Ribble Valley Borough Council
Housing & Development Control

Application no: **3/2023/0263**

Address: **Eaves Hall Moor Lane West Bradford BB7 3JG**

Proposal: **Construction of 15 eco lodges and infrastructure to provide additional accommodation for Eaves Hall (pursuant to variation of conditions 2 (Plans), 3 (Materials), 4 (Landscaping), 5 (Refuse/Cycle Store), 12 (Landscaping Scheme), 14 (Drainage Scheme), 15 (Surface Water Pollution), 16 (Surface Water Ponds), 19 (Construction Method Statement) and 22 (Bird/Bat Boxes) of planning permission 3/2020/0544) to reflect updated layout and change of lodge type and additional technical details submitted.**

1 Proposed Site Plan
Scale: 1:500

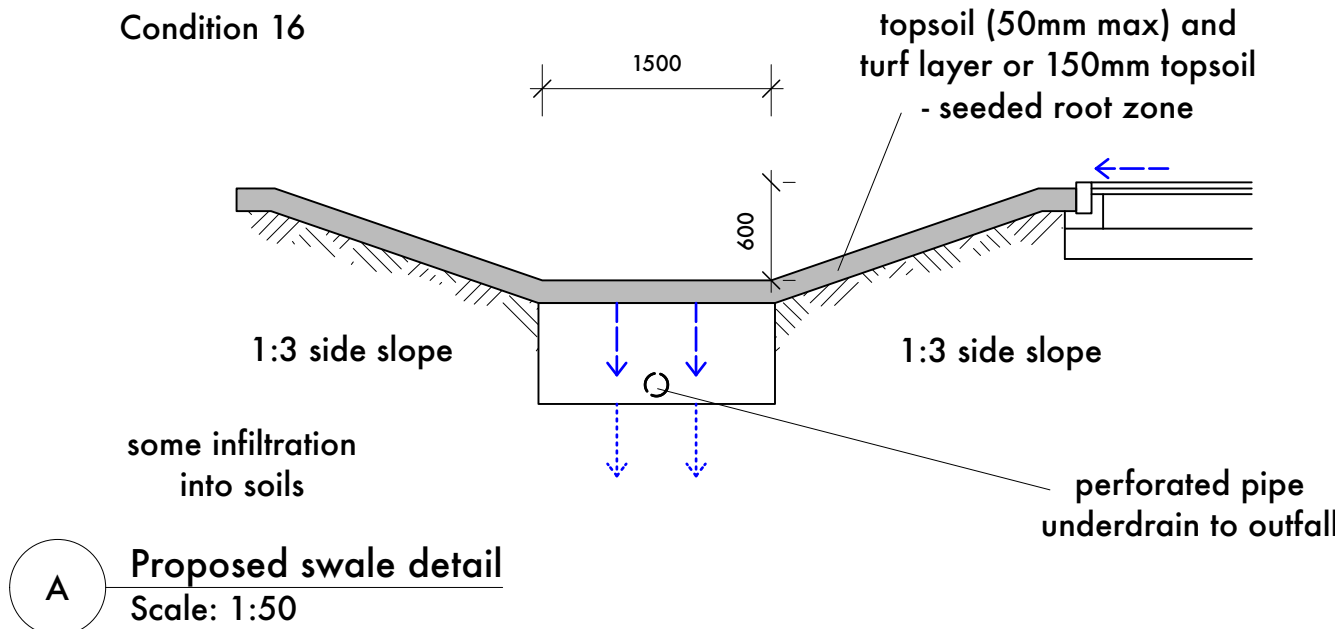
The LHA have reviewed the revised plans and have no objection to the Variation of Condition. However, the approved access will be subject to a section 278 agreement and the LHA require the Developer to contact the LHA in the first instance to discuss the application.
